SSD-70283710: 1 Crescent Street, Holroyd

Transport Impact Assessment - Response to Submissions

14 November 2025

- VEHICLE ENCROACHES EACH OTHER. CONFIRM PARKING AISLE WIDTH.

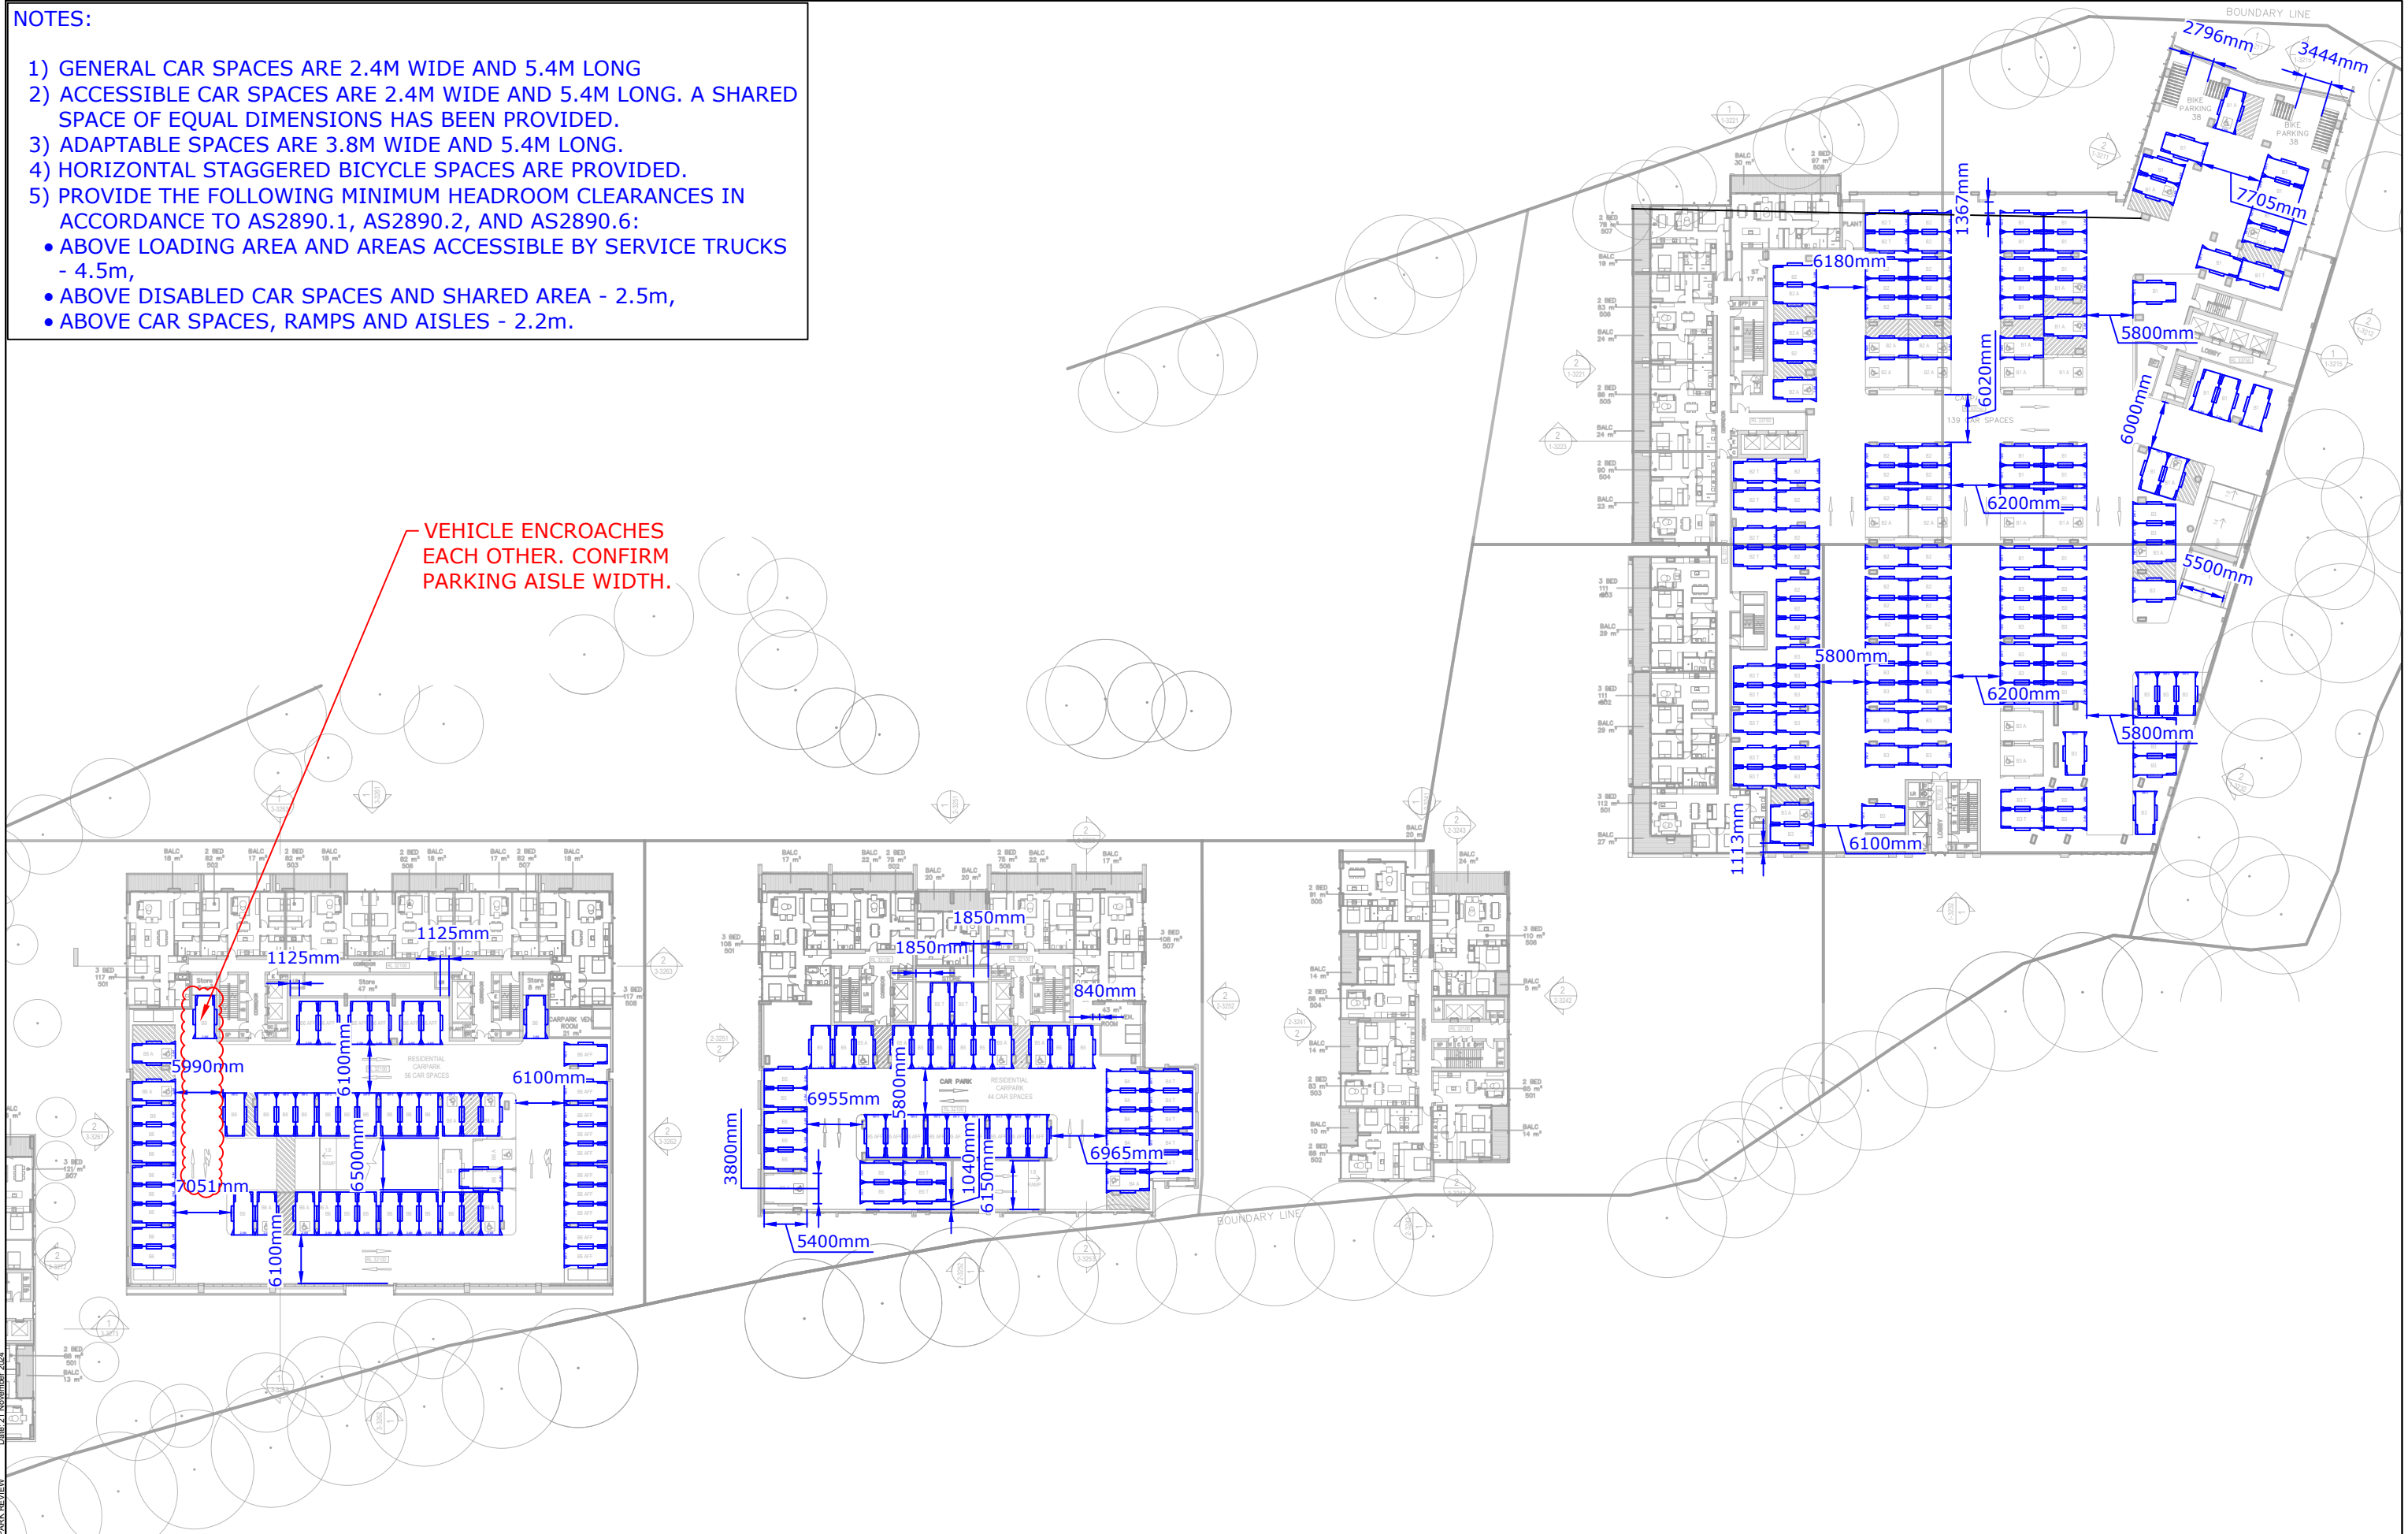
CC-25-1	Parking generally There is an absence of any motor cycle parking which is unrealistic, especially so for considering socio demographics and the number of occupants associated with affordable housing.	Motorcycle parking is not being provided. Potential at CC stage to convert car spaces to motorcycle spaces if required.	Section 5
CC-25-2	Parking generally Each of the parking spaces should be numbered according to the land-use user group for clarity. In addition, parking space provision for each parking level for each Block (phase) should be presented in a tabular form for clarity. The architectural plan of parking area does not provide clarity for review of provision.	The car parking plans have been updated. Parking spaces have been labelled as V for visitor, R for retail, C for commercial and B01, B02, B03 B04 for B05 for residential buildings and CW for car wash bays.	Section 5
CC-25-3	Parking generally The parking spaces and the aisle widths must be dimensioned appropriately for clarity. In addition, the finished floor level must also be shown on the floor plan and at each change of gradient. This includes the finished surface level at each change of gradient along the ramps."	Car park review has included dimensions. Residential aisles are 5.8m wide and 6.2m for retail which comply with AS2890.1. Dimensions of car spaces have been reviewed and checked by TTPP and are attached in Appendix B.	Section 5
